Project #: 1004720 Application #: 13DRB-70581
Project Name: HIGHLAND ADDN SOUTH
Agent: TERRA LAND SURVEYS LLC Phone #:

**CITY OF ALBUQUERQUE
PLANNING DEPARTMENT
June 26, 2013
DRB Comments**

RE: Lots 3 & 4, Block K, Highland Addition South

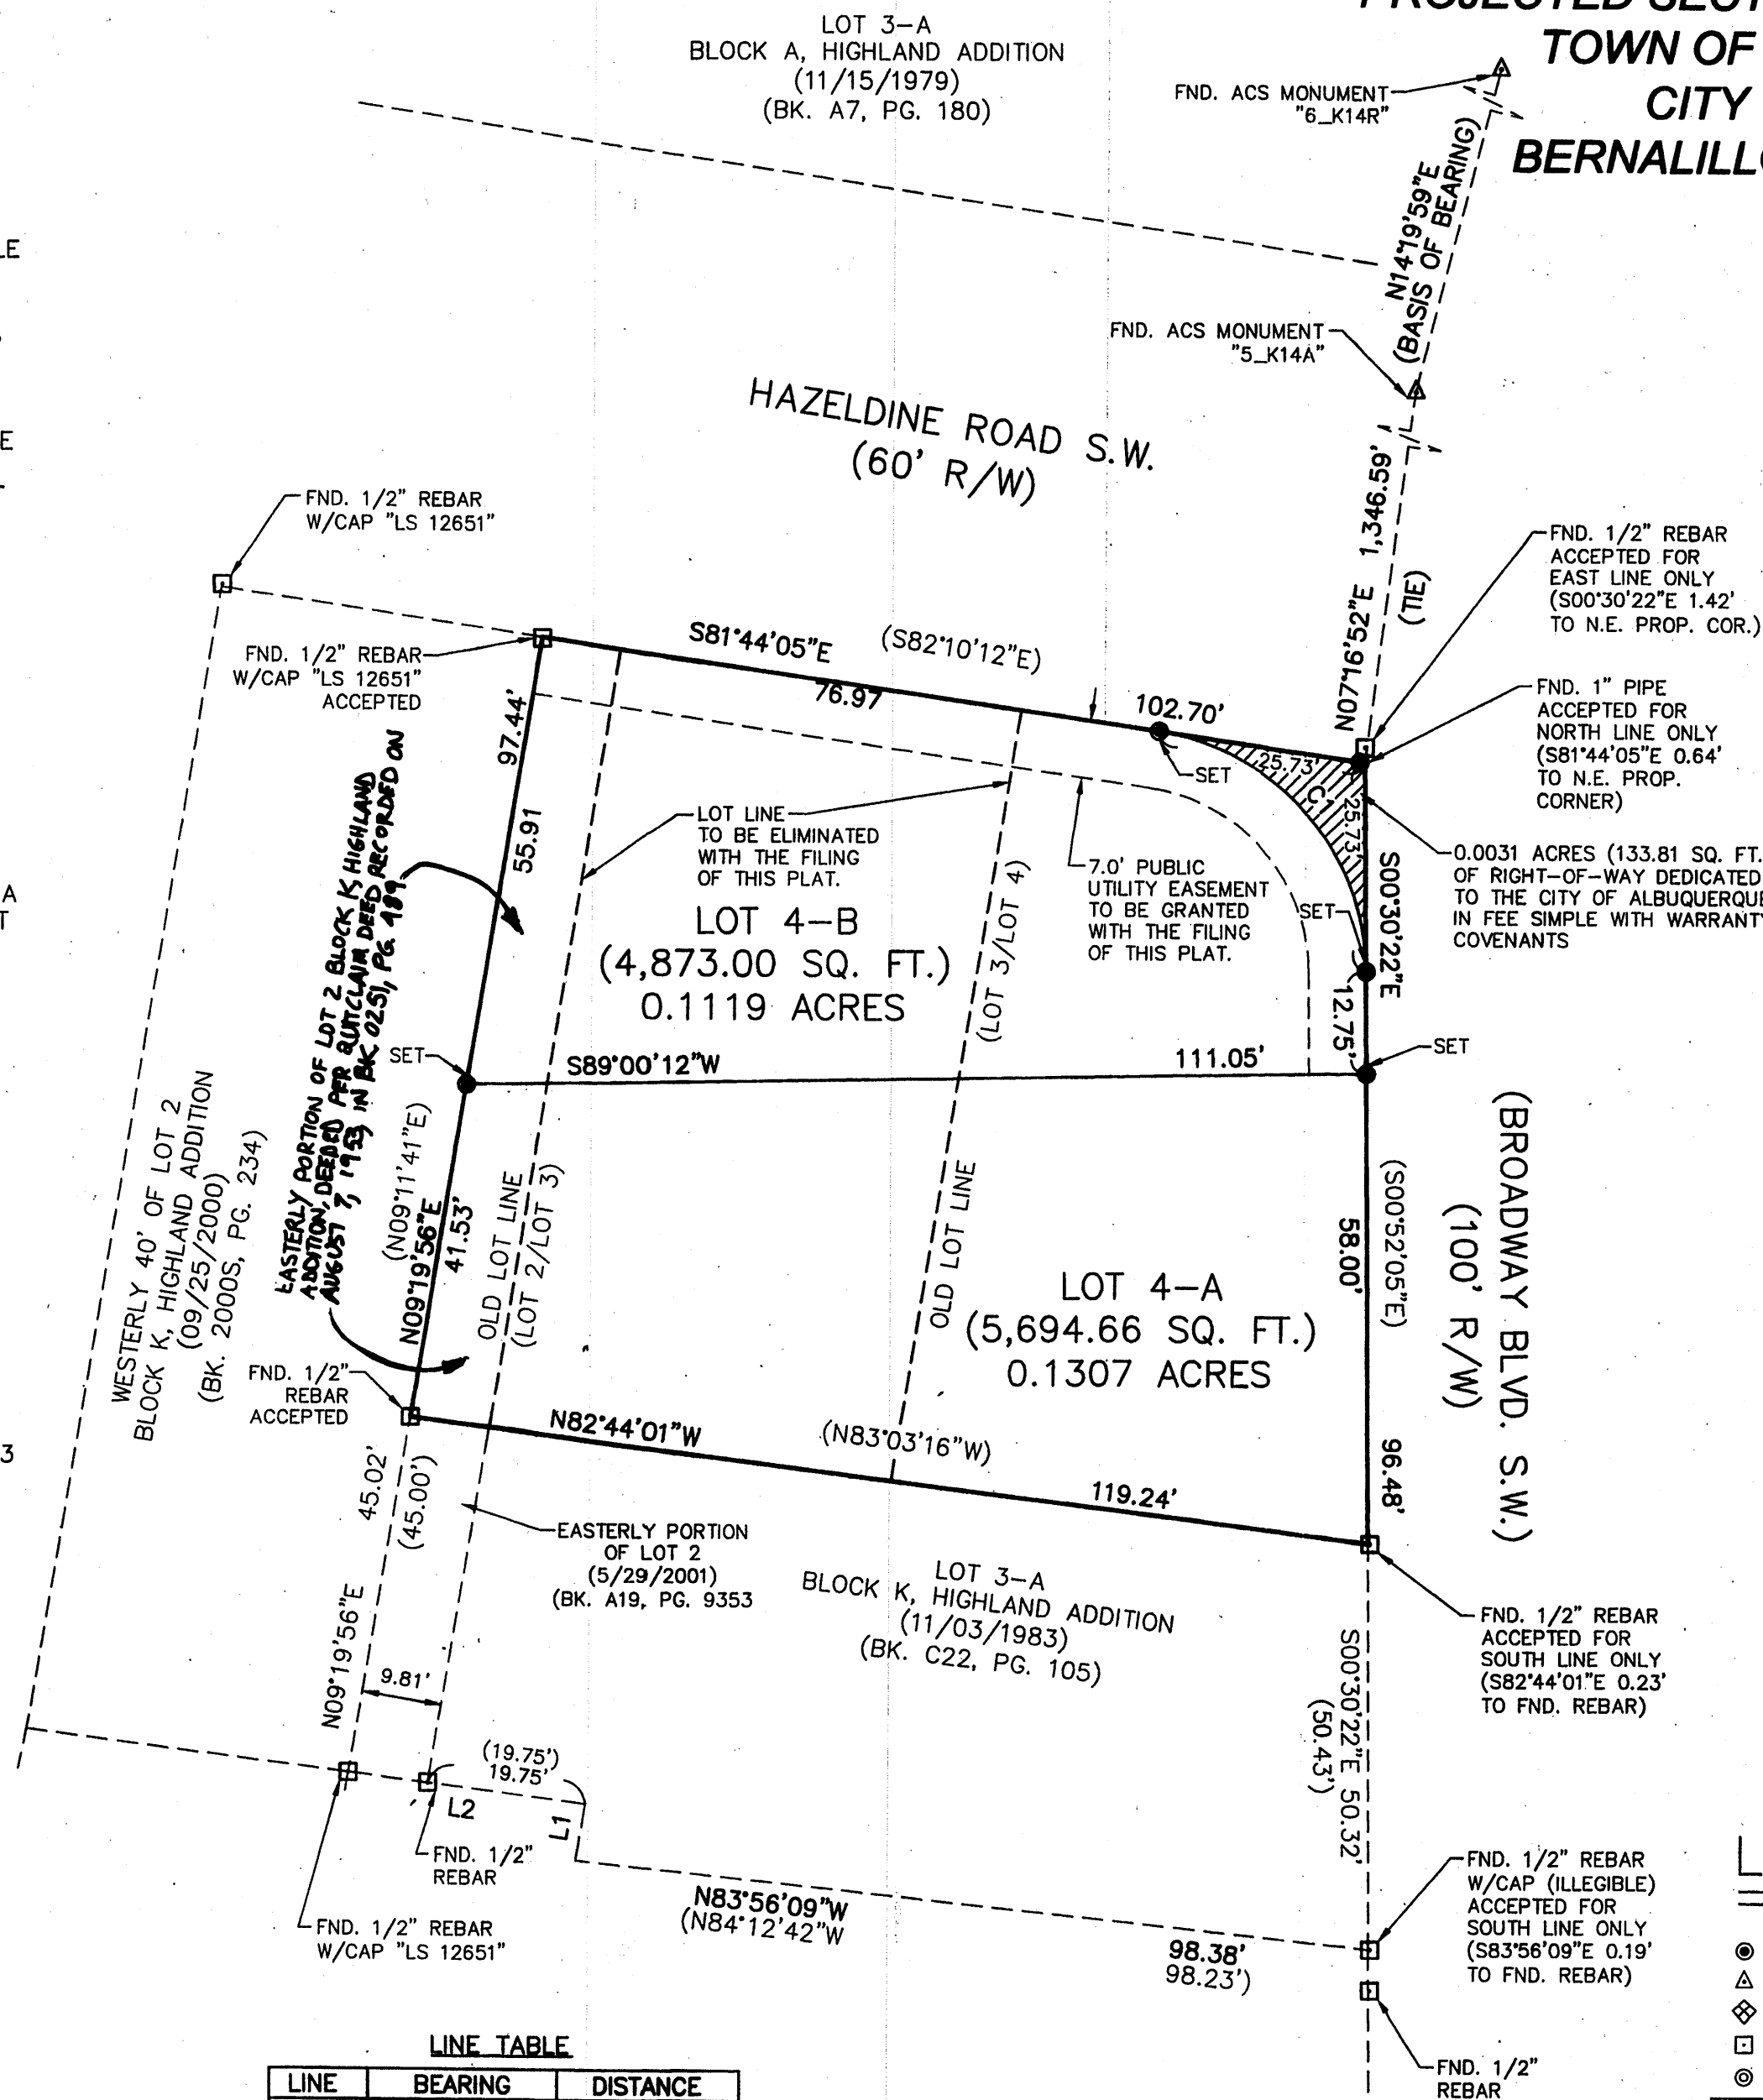
- TRANSPORTATION:
- ABCWUA:
- CITY ENGINEER / AMAFCA:
- PARKS / CIP:
- PLANNING (Last to sign): show / call out "Pre 1973" Needs on plat drawing

The appropriate adjoiner reference on the plat drawing needs to include "Pre – 1973" Deed(s). Please provide a copy of the deed(s).
